A303 Sparkford to Ilchester Dualling Scheme TR010036

8.4 Draft Statement of Common Ground with Somerset County Council and South Somerset District Council

STATEMENT OF COMMON GROUND

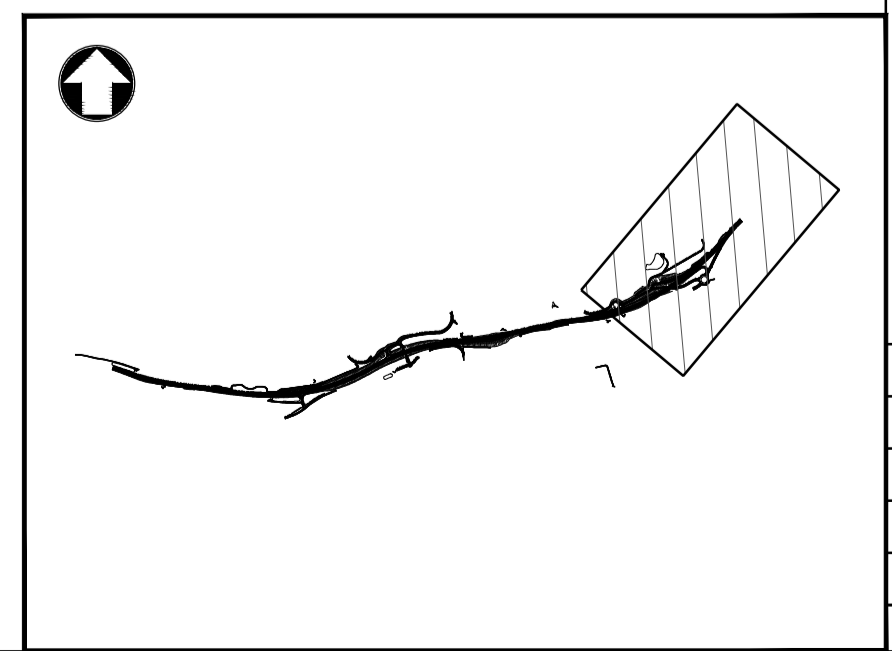
Lighting	Responsibility for proposed system of lighting at Hazlegrove Roundabout is yet to be resolved, although SCC's view at this time is that Highways England would retain maintenance responsibility.	-	<i>UNDER DISCUSSION</i>
Drainage	Detailed drainage proposals confirming that only surface water runoff from the local highway network discharges to Pond 4 will need to be submitted before SCC are able to accept maintenance responsibility for this pond. Further consideration of	The dDCO provides at Requirement 12 that the detailed design will be submitted to the Secretary of State for approval following consultation with the relevant planning authority and local highway	<i>UNDER DISCUSSION</i>
